Your ref: 3/2020/0525
Our ref: DC/20/2685
Date: 10-AUG-20

Location: Plane Tree Farm, Chipping Road, Chaigley, BB7 3LT
Proposal: Installation of new feed storage bin

Title: Site Plan

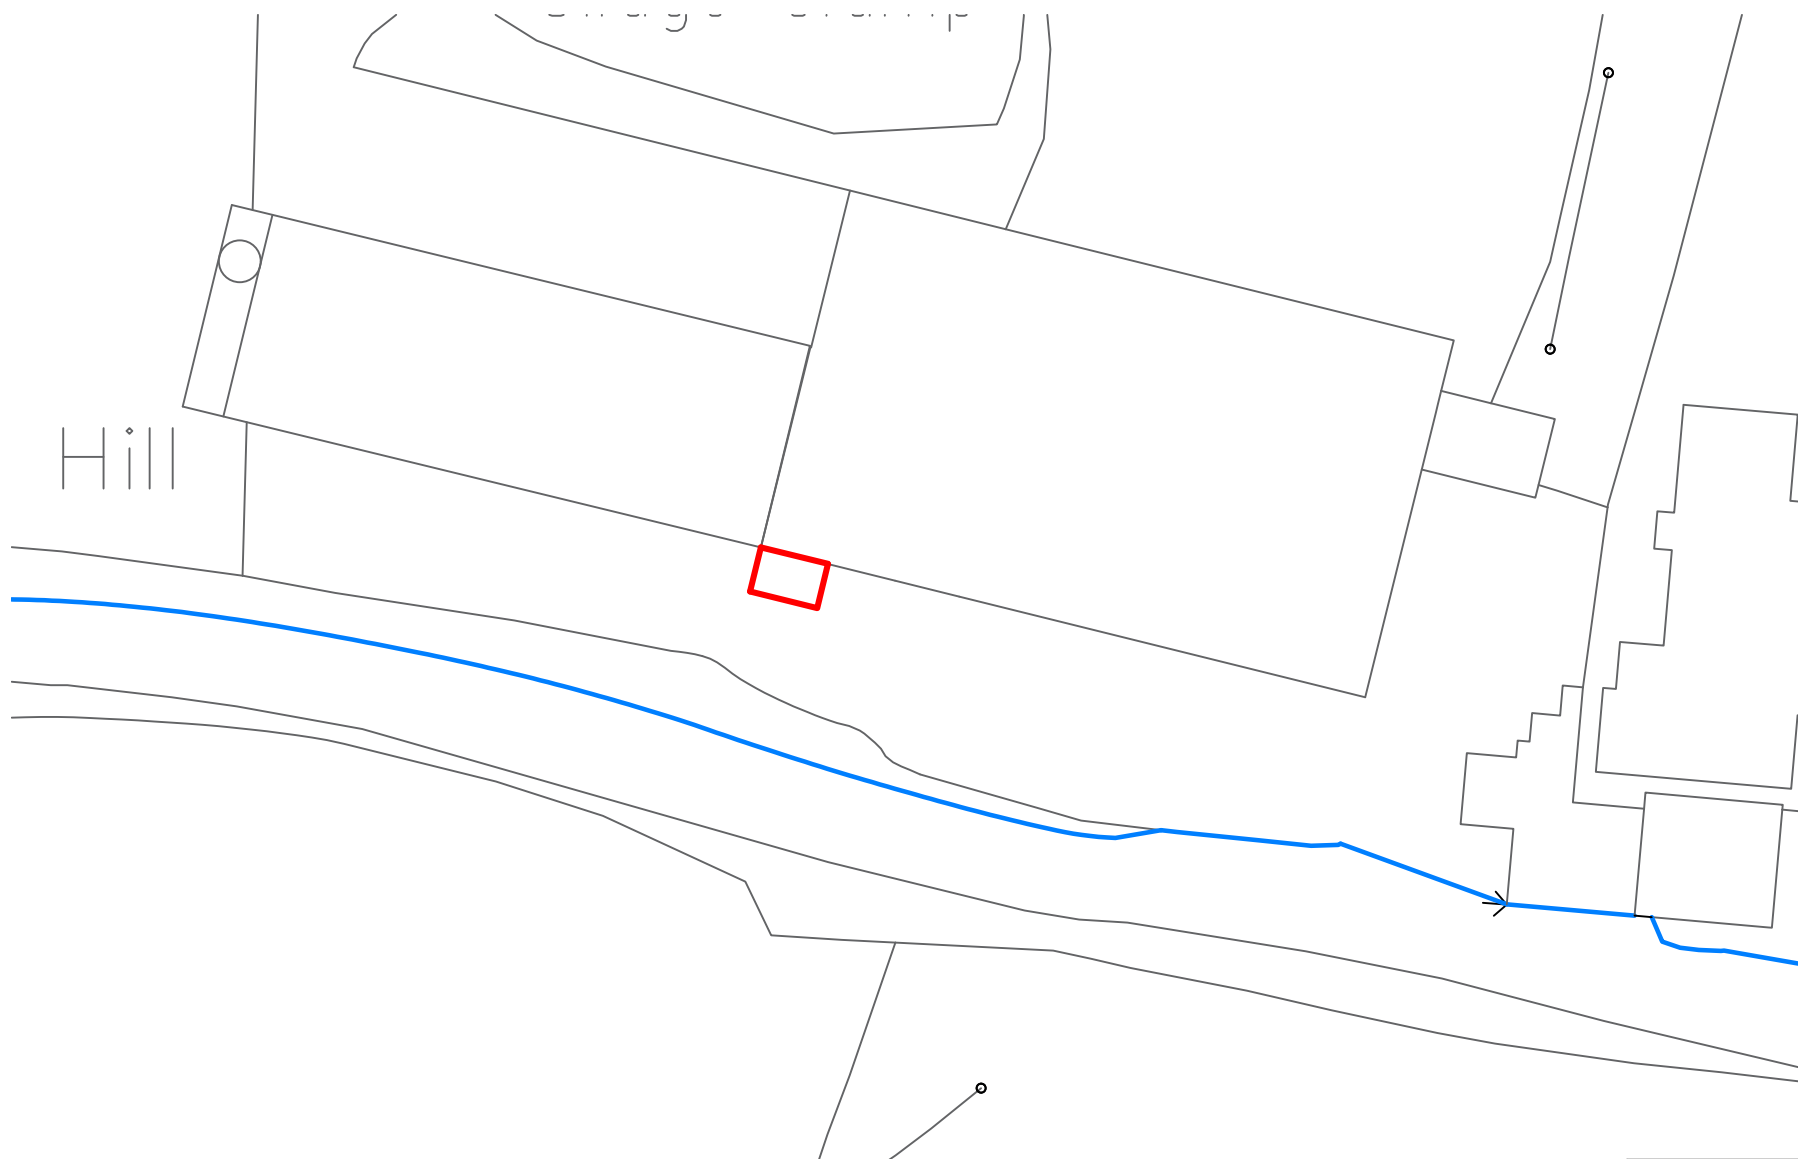
United Utilities wishes to **OBJECT** to the proposed development. The proposed feed silo appears to be over or in close proximity to our strategic large diameter water main. This is a major pressurized water supply asset and as we need **unrestricted** access for operating and maintaining it, we will not permit development over or in close proximity to the main. We require an access strip as detailed in our '*Standard Conditions for Works Adjacent to Pipelines*', a copy of which is enclosed. We therefore recommend that the applicant contacts Water Developer Services at DeveloperServicesWater@uuplc.co.uk so the precise location of the main on-site can be determined and the impact of the proposed development on our asset fully considered **prior to determination**. We would also wish to agree any approach to construction near our water main.
